**APPLICATION BY HIGHWAYS ENGLAND FOR AN ORDER GRANTING
DEVELOPMENT CONSENT FOR THE A428 BLACK CAT TO CAXTON GIBBET
IMPROVEMENTS**

APPLICATION REF: TR010044

**REPRESENTATIONS OF THE HISTORIC BUILDINGS AND MONUMENTS
COMMISSION FOR ENGLAND (HISTORIC ENGLAND)**

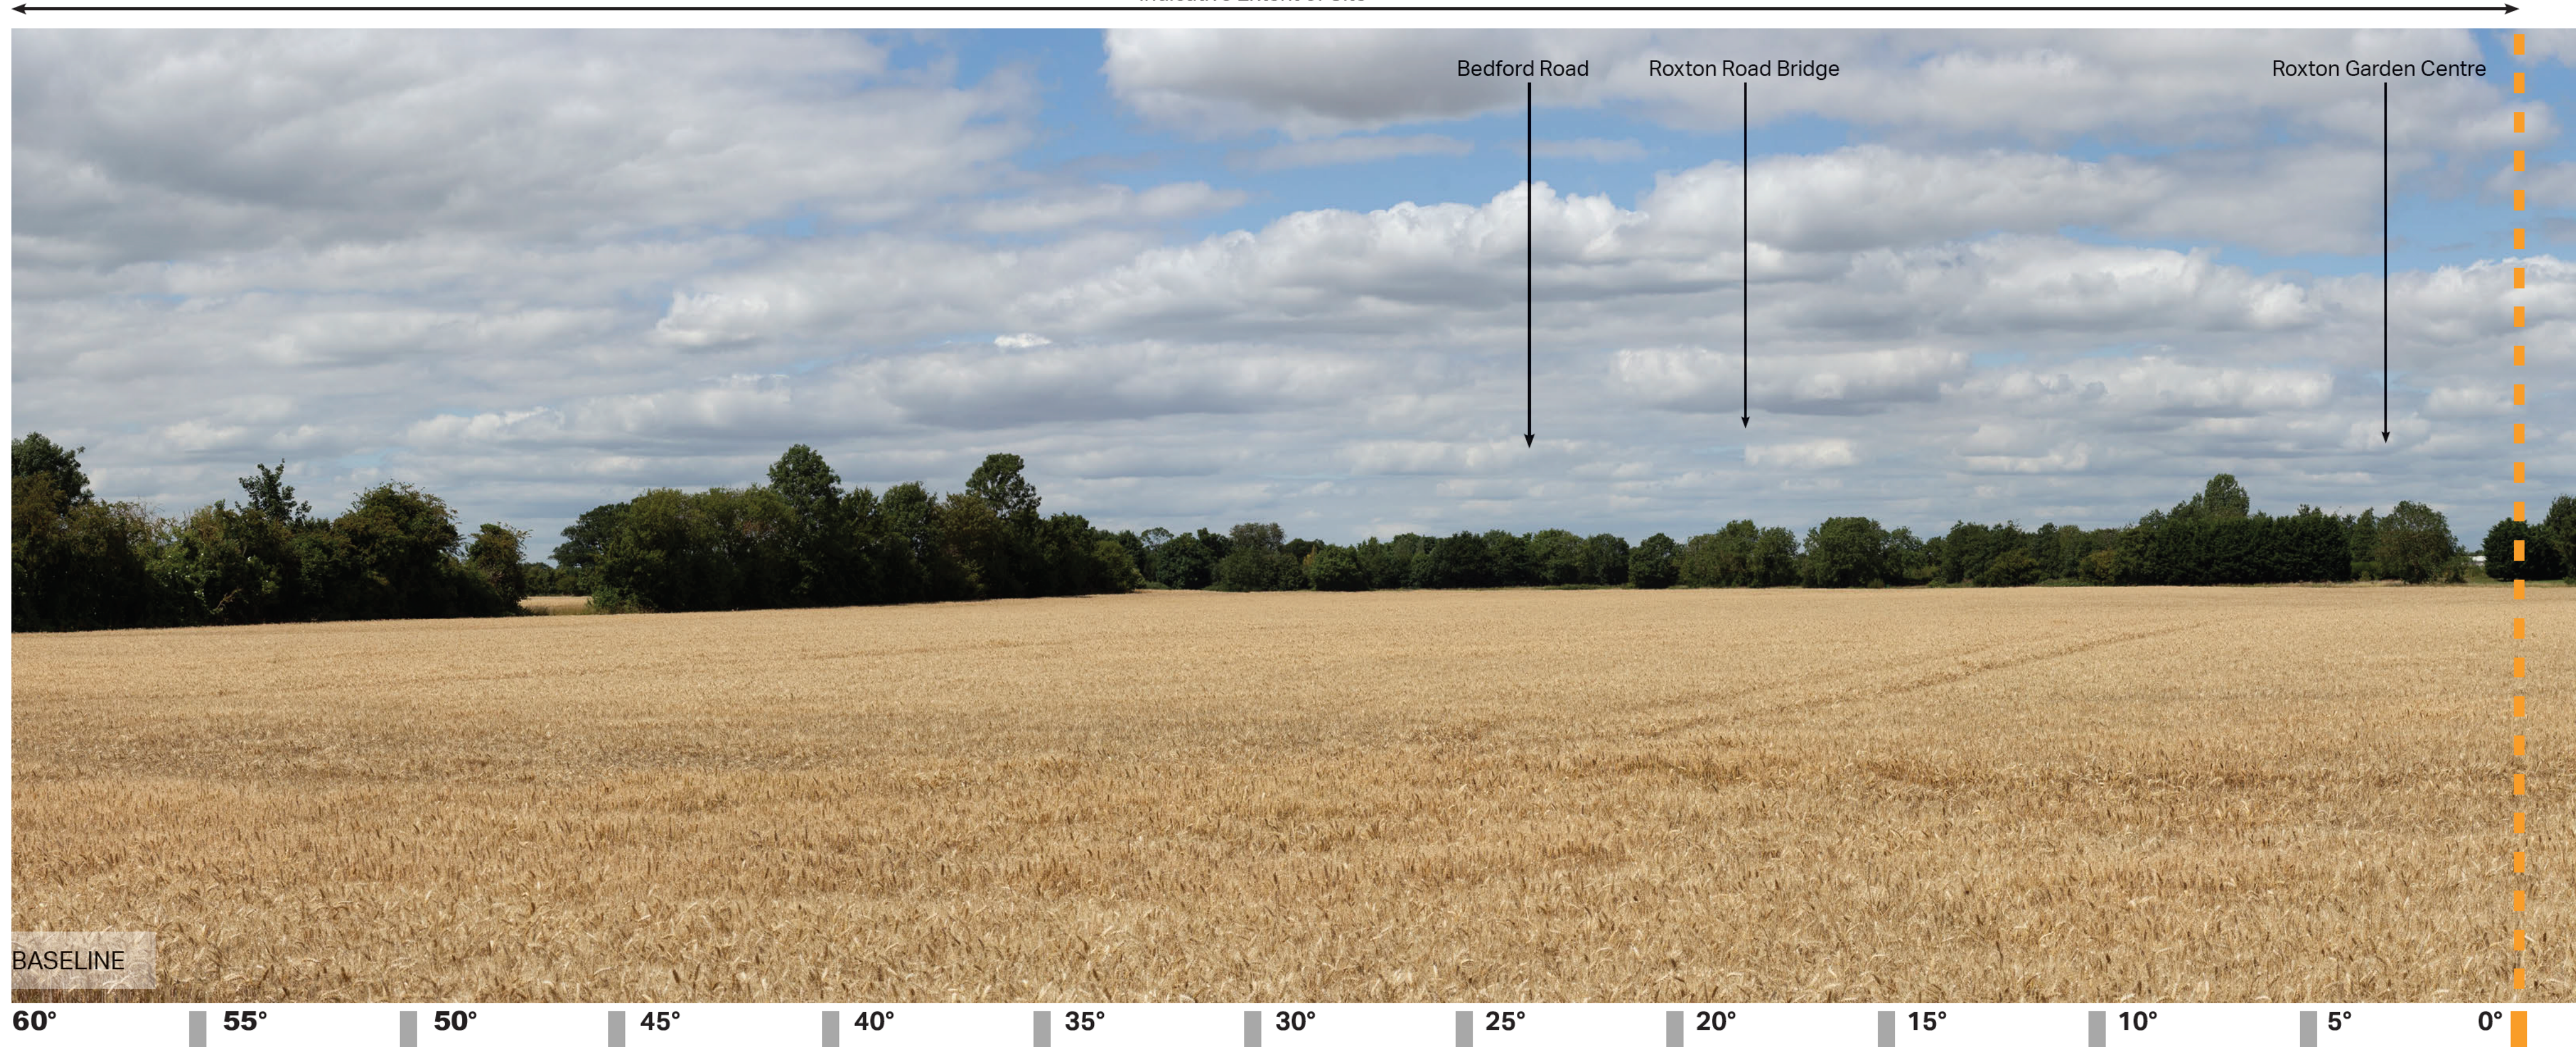
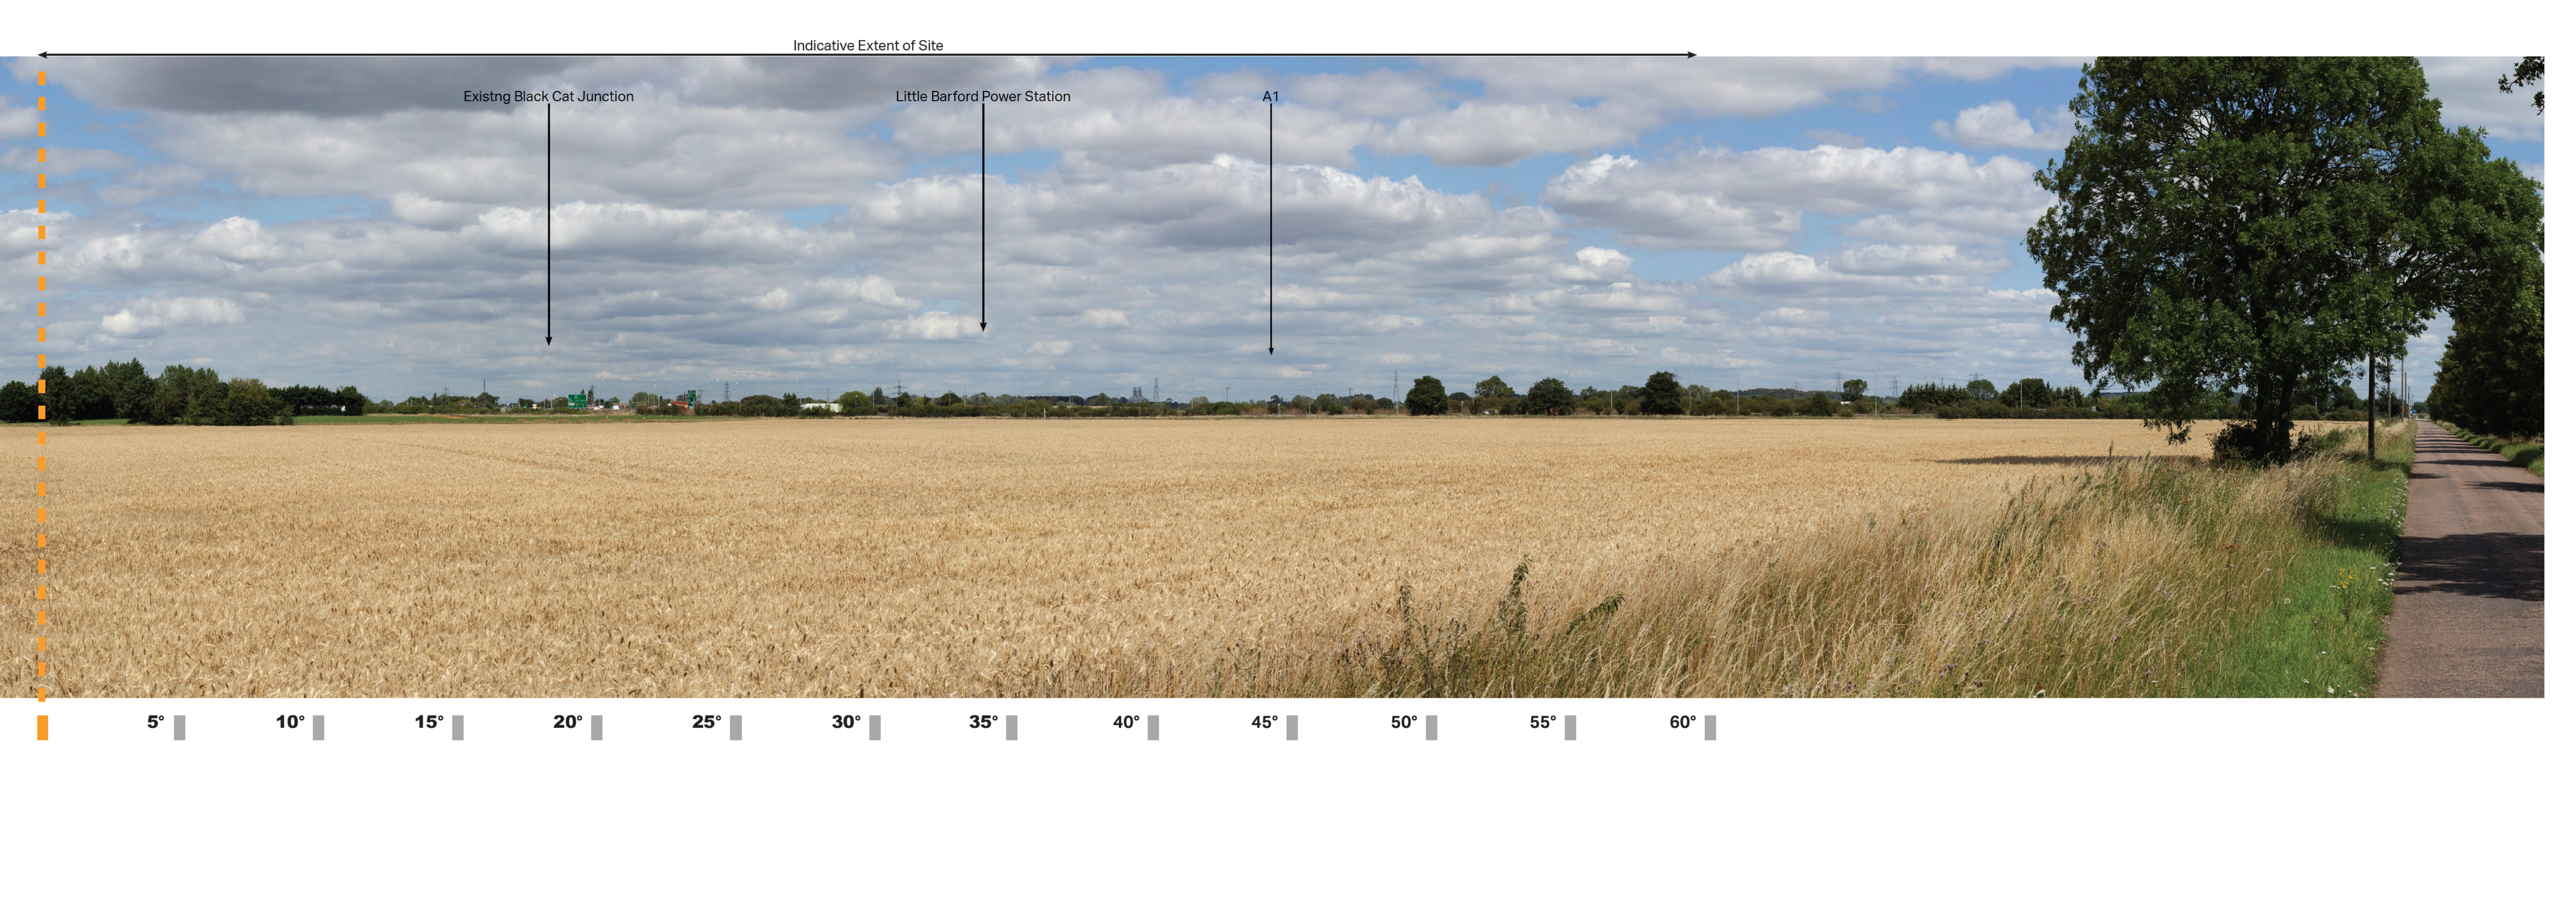
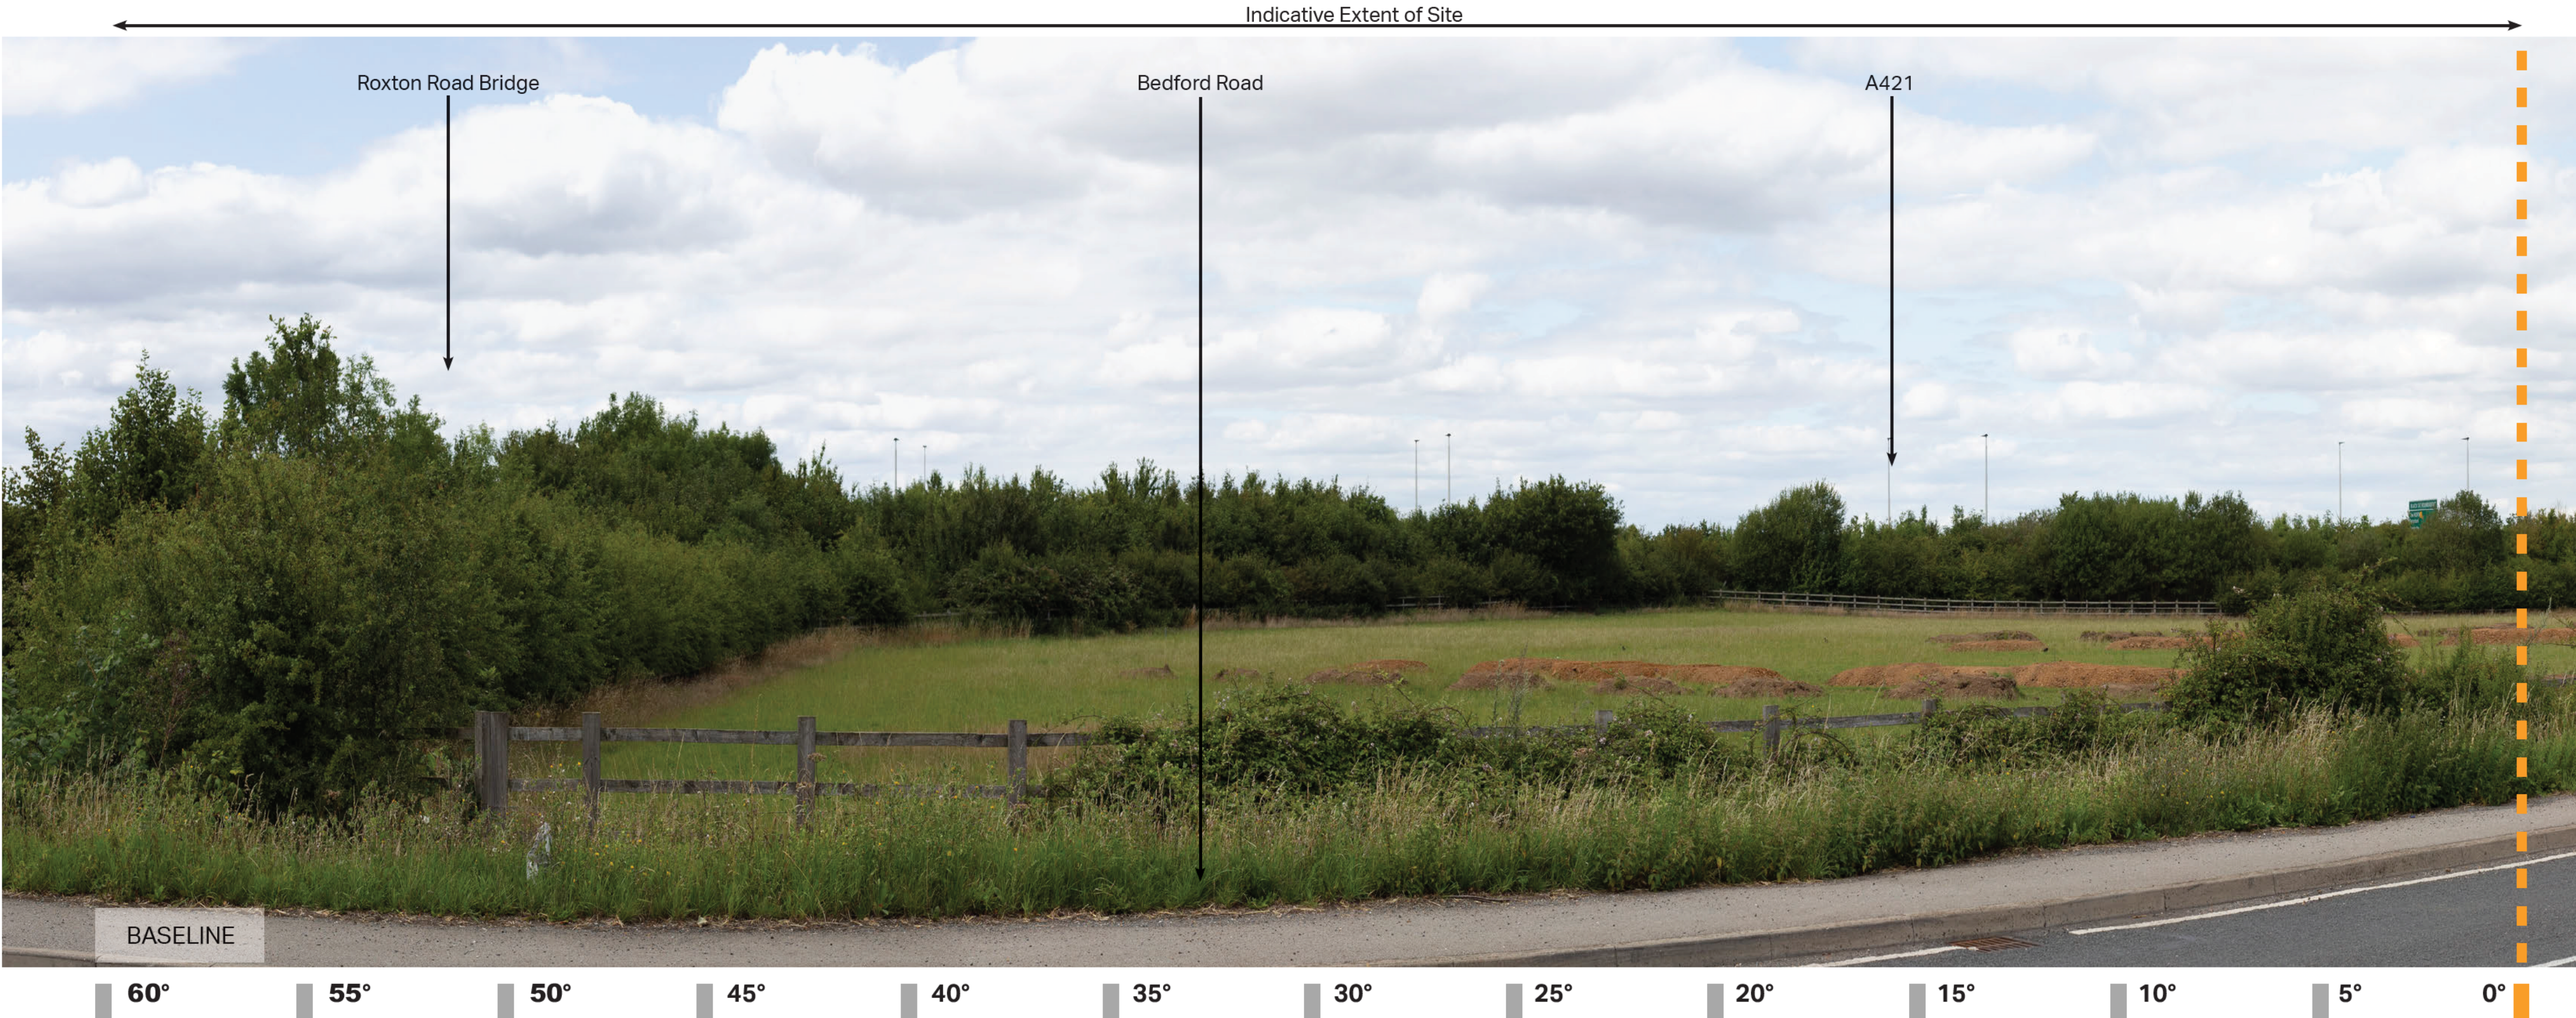
- 3.8 However, the registered park itself and the Scheduled medieval village border the existing A428 and so are closer to the proposed line of the road than some of the listed buildings within the park. The image from viewpoint 44 (Figure 7.15.43.01 - 7.15.46.04 in ES 6.2 Photomontages) looks from the edge of North Lodge Plantation which stands in the fields across the A428 from the registered park. It shows the road partly in a cutting but with the existing Toseland Road crossing it on a bridge and vehicles visible on the main carriageway to the west. The park can still be experienced in views across the A428 from the area in which the photograph was taken and so it forms part of its setting. We have questioned the significance of this part of the setting and the effect the development could have on its rural quality.

- 3.10 The possibility of this area being a late extension to Croxton park overlaying fields around the medieval village is an interesting one which could increase its historic significance. Regardless of this, it remains part of the setting of the registered park and scheduled medieval village and we would consider the presence of the road seen in viewpoint 44 could reduce the rural quality of this part of the setting and potentially harm the designated heritage assets. Placing this in terms of the National Networks National Policy Statement we conclude this would be 'less than substantial' harm under paragraph 5.134. We would therefore question the conclusion in the ES, chapter 6, 6.9.272 that these heritage assets would 'experience no change' amounting to 'no harm to significance' and that a 'slight beneficial effect' would result overall and also that in document 7.1 Case for the Scheme paragraphs 5.5.10 and 5.5.32 which suggest an overall enhancement to the registered park. To mitigate this effect landscaping is proposed which would reduce the visibility of the road and reduce traffic noise. However, even After 15 years the image from viewpoint 44 suggests the road bridge would still be seen. We would therefore encourage additional landscaping to further reduce the impact, perhaps by a greater depth of planting.
